Nathan Clifford

Code Review

**180 Falmouth Street
Portland, Maine**

February 25, 2014

1 TYPICAL EXISTING STAIR PLAN

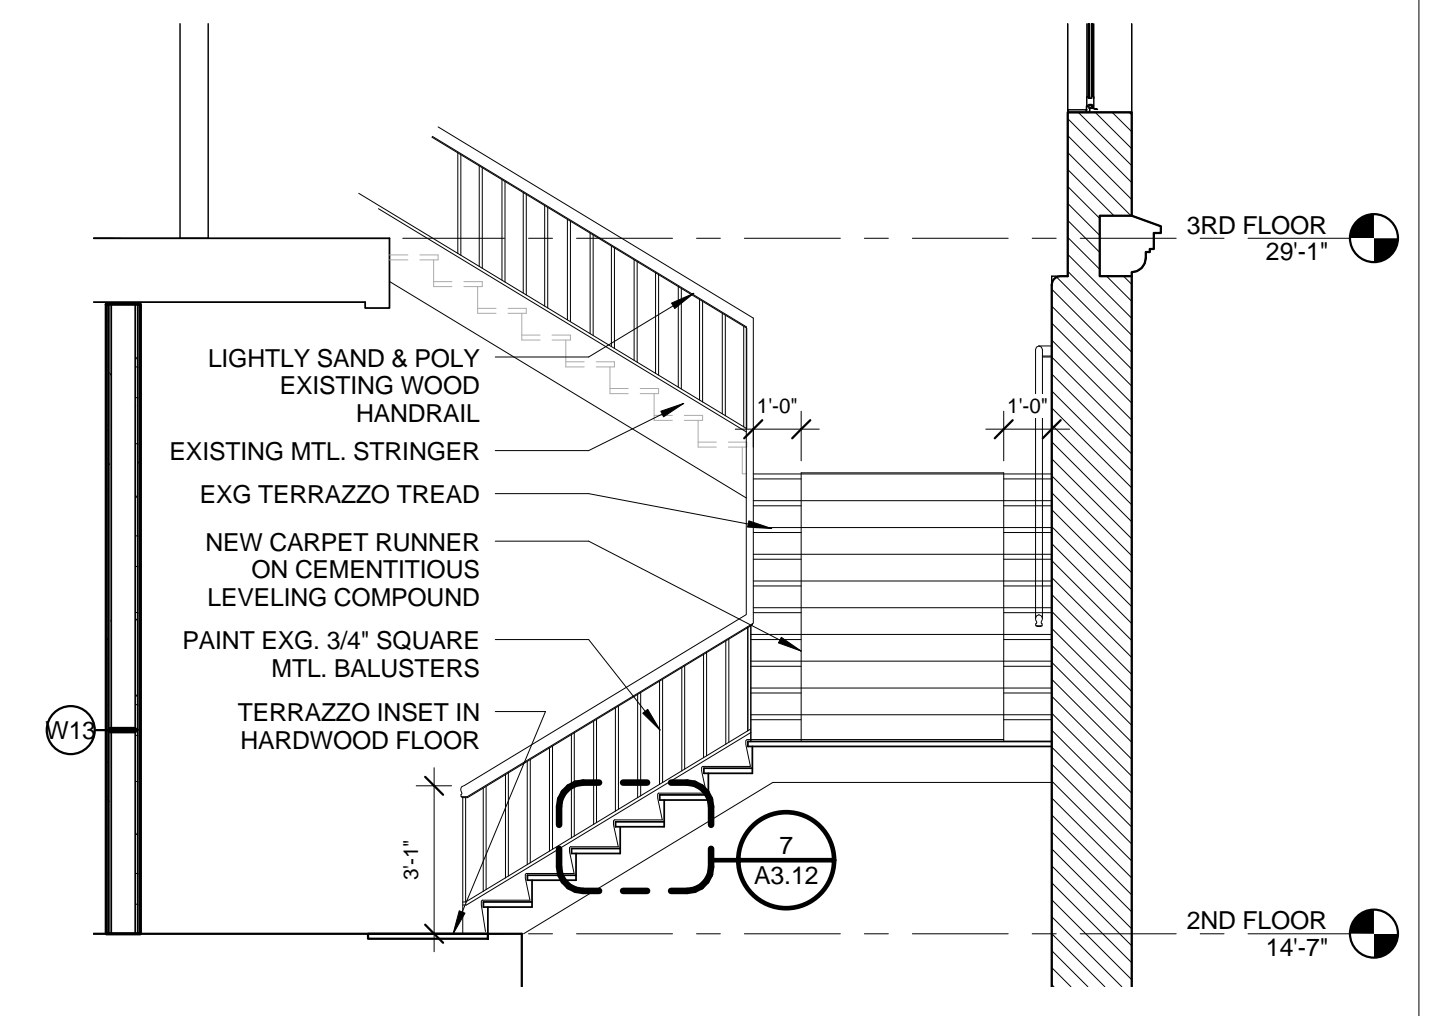
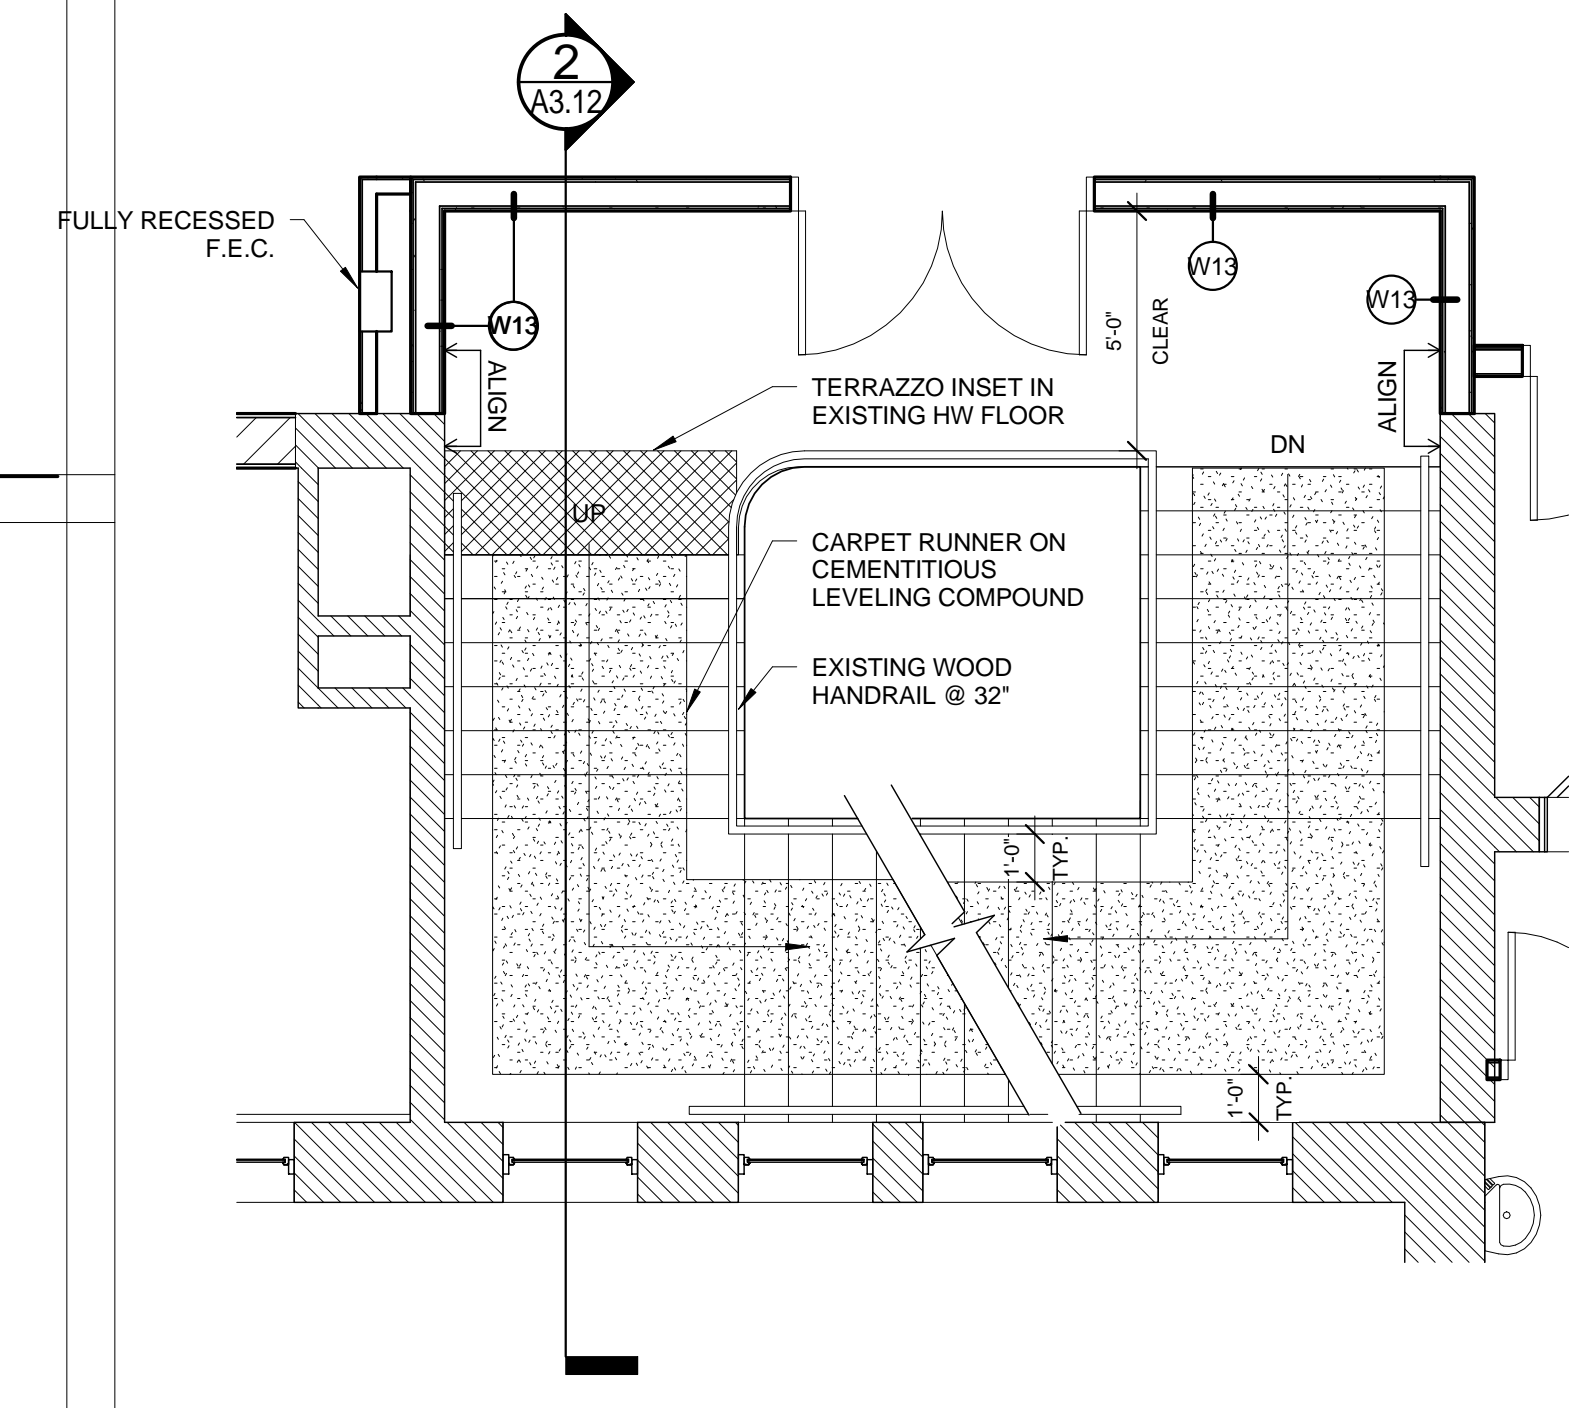
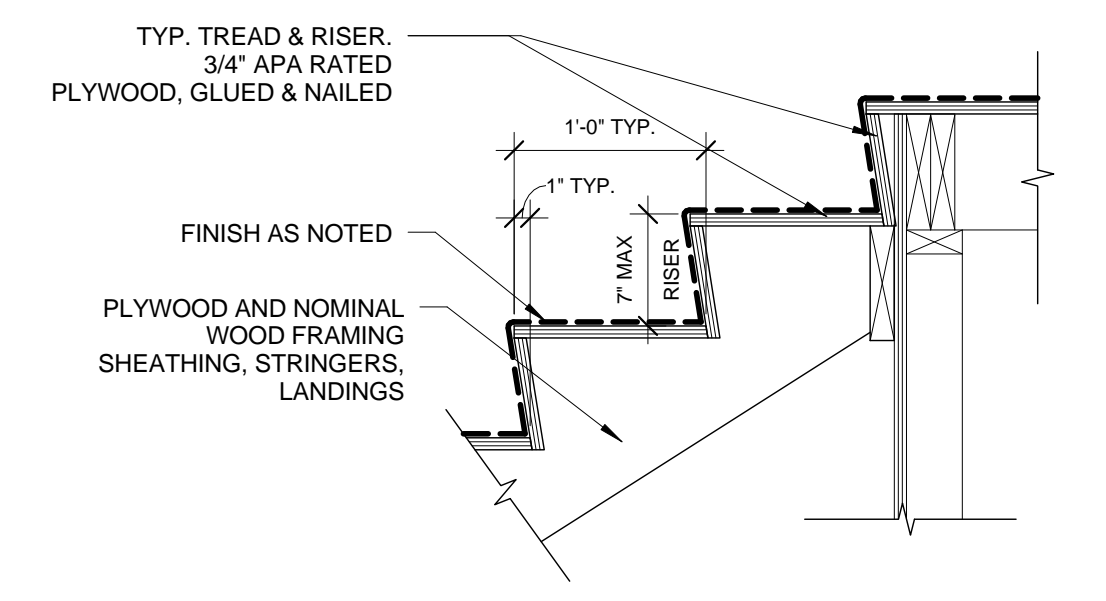
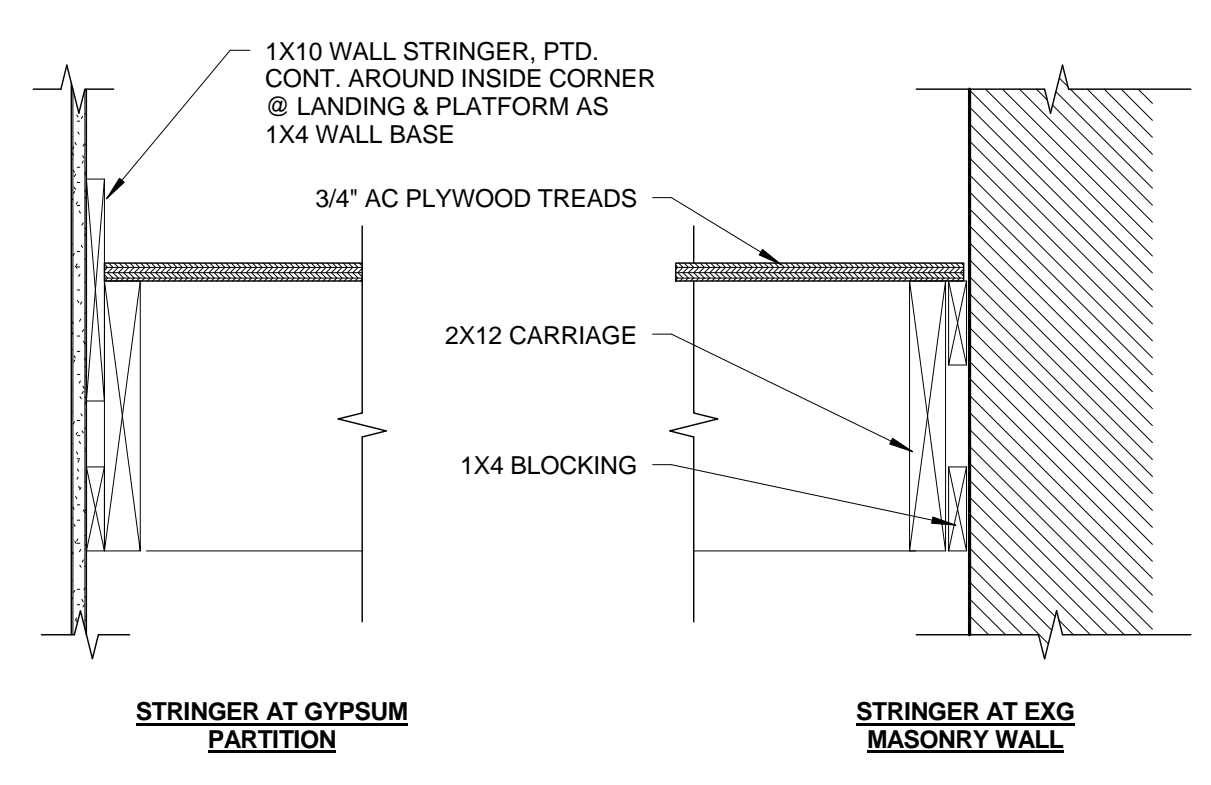
1. With respect to the handrails, is it necessary to add a handrail in the middle of the stair well?

This was reviewed. According to the drawings, the width of the stair between the handrails on either side is 5'-5" (65") in Stair A and Stair B. In the International Existing Building Code (IEBC), Chapter 9, Change of Occupancy, Section 912.4.4

states that Handrails shall comply with the requirements of 705.9, Handrails. Section 7.5.9.1, Minimum requirement, states that every required stairway that is a part of a means of egress...shall be provided with handrails for the full length of the run of the steps on at least one side. All exit stairways with a required egress width of more than 66 inches shall have a handrail on both sides.

The Life Safety Code, Section 7.2.2.4.1.2 (2), states that for existing stairs, Handrails are required within 44 inches of all portions of the required egress width.

While there is no direct statement that addresses the specific situation in the Nathan Clifford building, it is *FIREPRO*'s professional opinion that the above information can be interpreted to mean that a center handrail is not required.

1 | WALL TYPE 1 - 9 1/4" UNIT DEMISING WALL
1 1/2" = 1'-0" 0 3 6 12 24

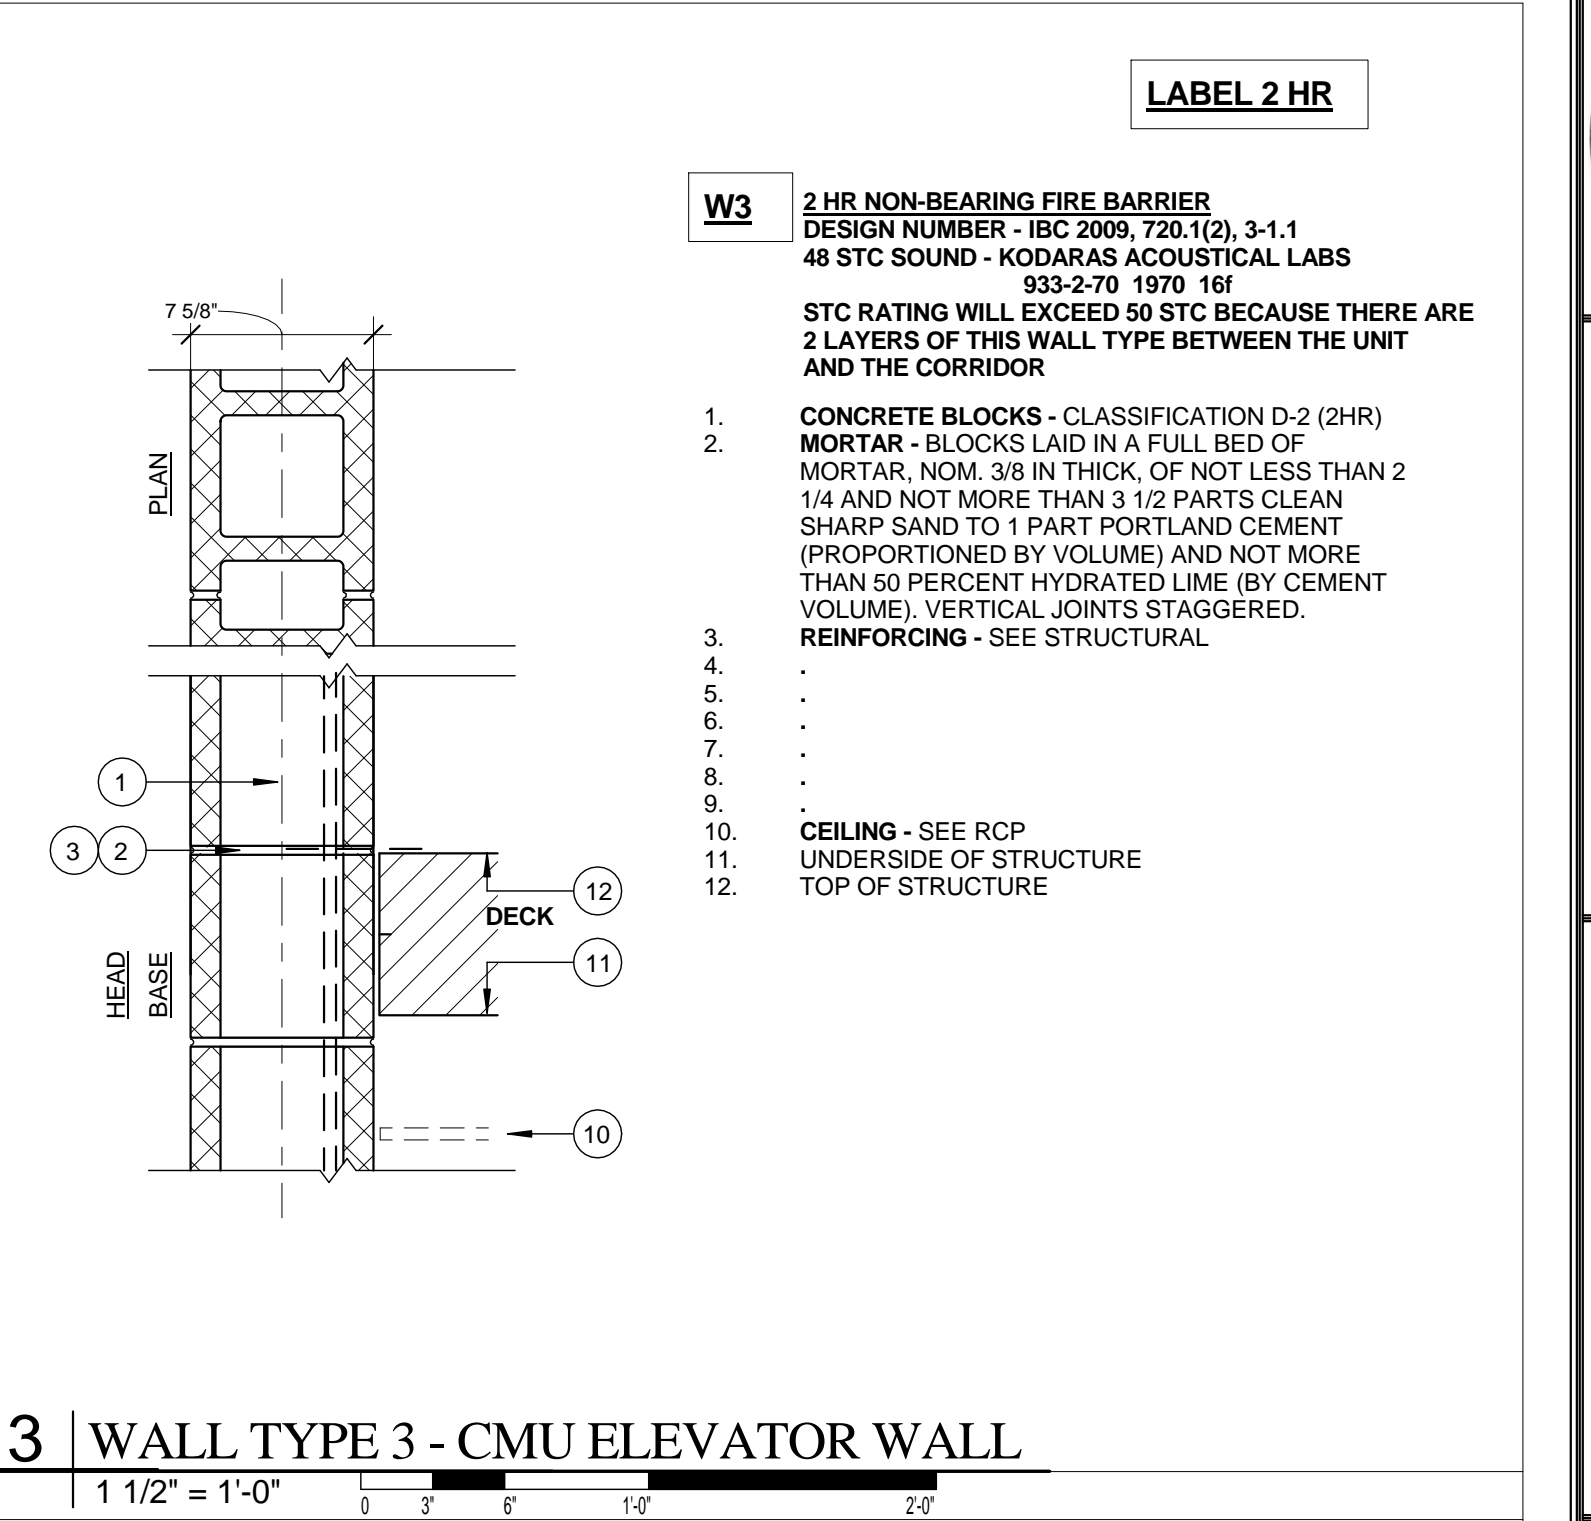
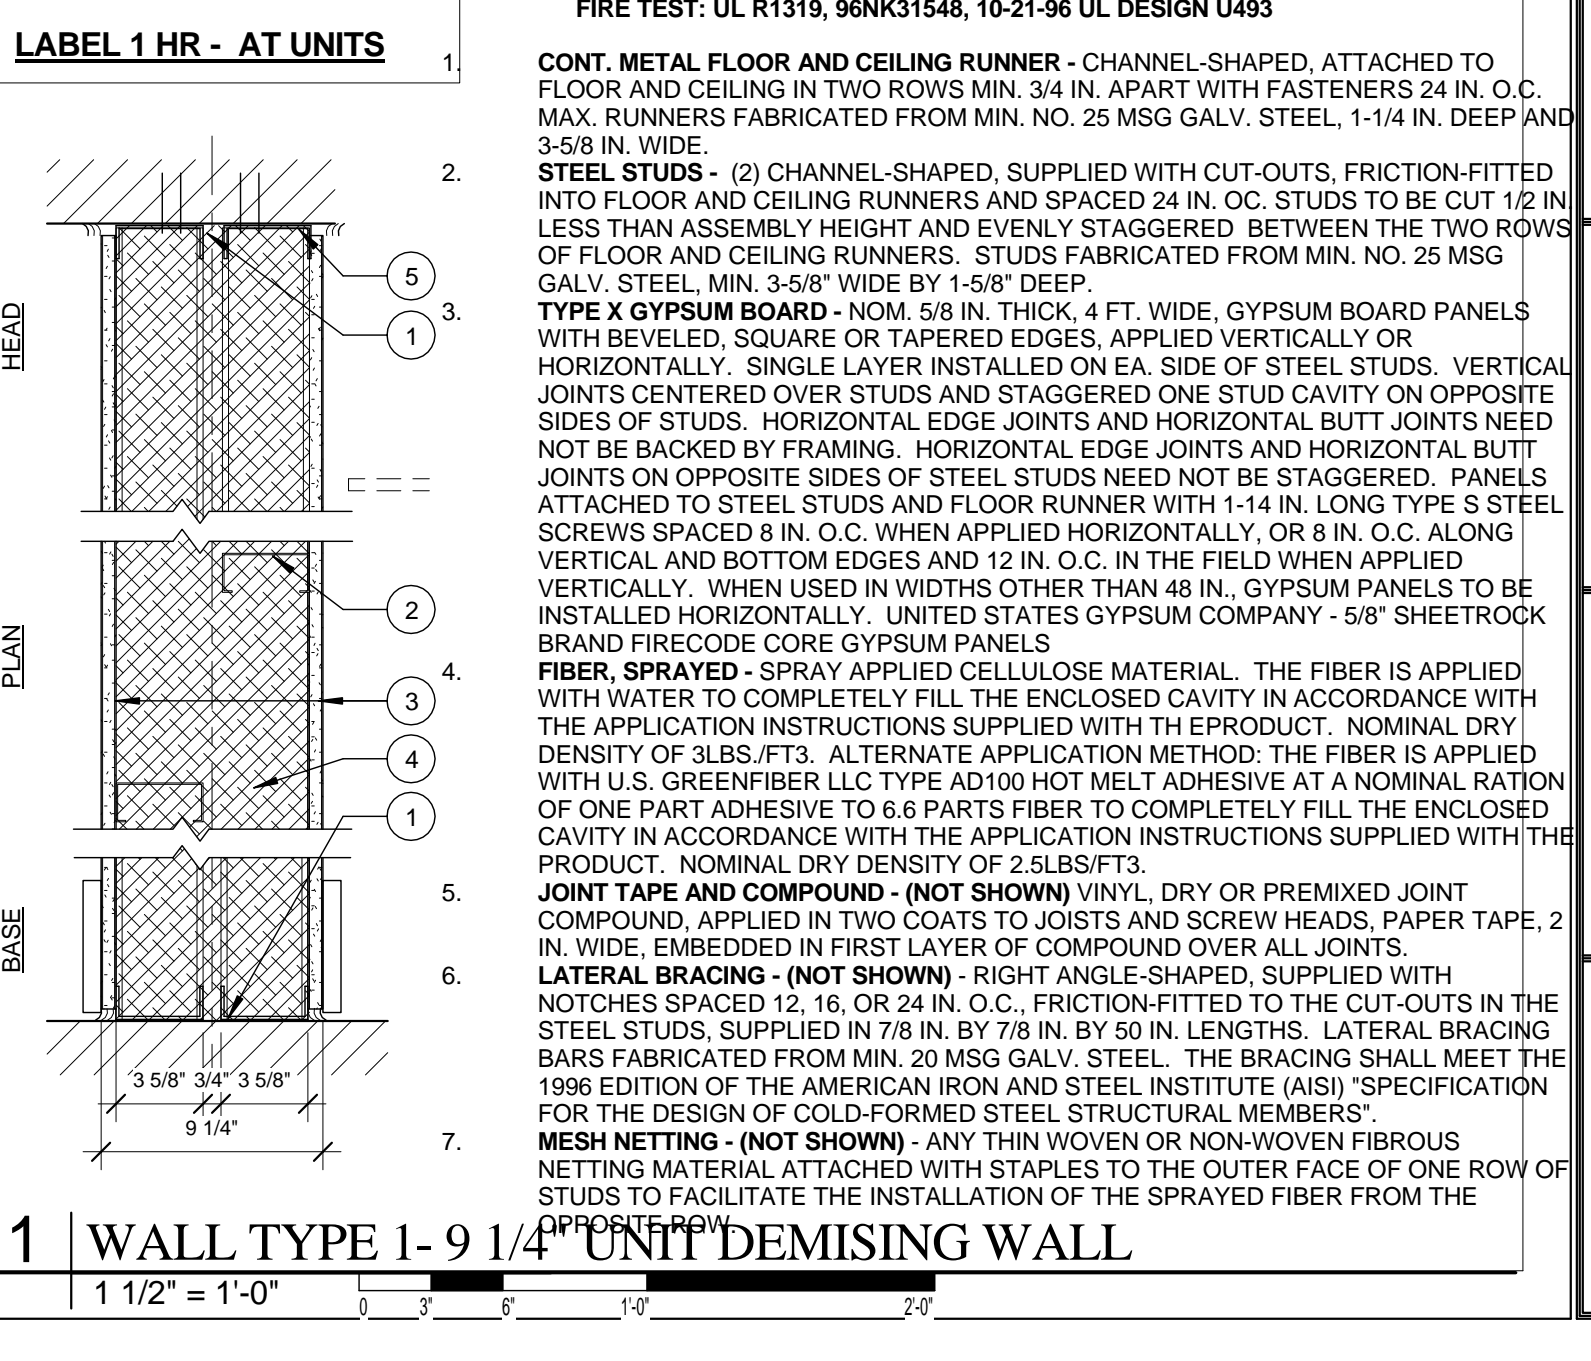
In accordance with the MUBC, Section 708.4, because there are four floors in the building, shaft enclosures must have a fire rating of two hours. A review of the drawings shows that all shaft enclosures will have a rating of two hours.

Corridor Fire Partitions (Non Brg): ½ hour	<i>Table 1018.1 & Sect 709.3 Ex.1</i>
Corridor Doors: 0.33 hour in 1-hour wall	<i>Table 715.4</i>
Corridor Doors to have smoke control	<i>Sect. 715.4.3.1</i>
Dwelling Unit Wall Separation: 1 hour	<i>Sect. 709.3</i>
Floor Assembly between Dwelling Units: 1 hr	<i>Sect 712.3</i>

MUBC Section 420.2 states that walls separating dwelling units in the same building and walls separating dwelling units from other occupancies contiguous to them in the same building shall be constructed as fire partitions in accordance with MUBC Section 709. MUBC Section 420.3 states that floor assemblies separating dwelling units in the same building and floor assemblies separating dwelling units from other occupancies contiguous to them in the same building shall be constructed as horizontal assemblies in accordance with MUBC Section 712.

MUBC Section 709.3 states that fire partitions shall have a fire resistance rating of not less than one hour. Exception 1 allows corridor walls to have a rating of ½ hour. Exception 2 allows dwelling unit separation in buildings of Type IIIB construction to have a fire resistance rating of not less than ½ hour in buildings equipped with an automatic sprinkler system in accordance with Section 903.3.1.1. Because the sprinkler system in the Nathan Clifford building is a 13R system, the exceptions in Section 709.3 do not apply, and the fire partitions must have a fire resistance rating of one hour.

MUBC Section 712.3, last sentence, states that horizontal assemblies separating dwelling units in the same building shall be a minimum of one hour fire-resistance-rated construction. The Exception to this section states that dwelling unit separations in buildings of Type IIIB construction shall have fire resistance ratings of not less than ½ hour in buildings equipped throughout with an automatic sprinkler system in accordance with Section 903.3.1.1, if an NFPA 13 sprinkler system is used. Because the sprinkler system in the Nathan Clifford building is a 13R system, the exception in Section 712.3 does not apply, and the horizontal (floor) assemblies must have a fire resistance rating of one hour.

A review of the drawings indicates that the fire resistance of the Corridor Fire Partitions, the Corridor Doors, the Dwelling Unit Wall separation and the Floor Assemblies will have the required rating; and that the Corridor Doors will meet the requirements for a smoke and draft control assembly.
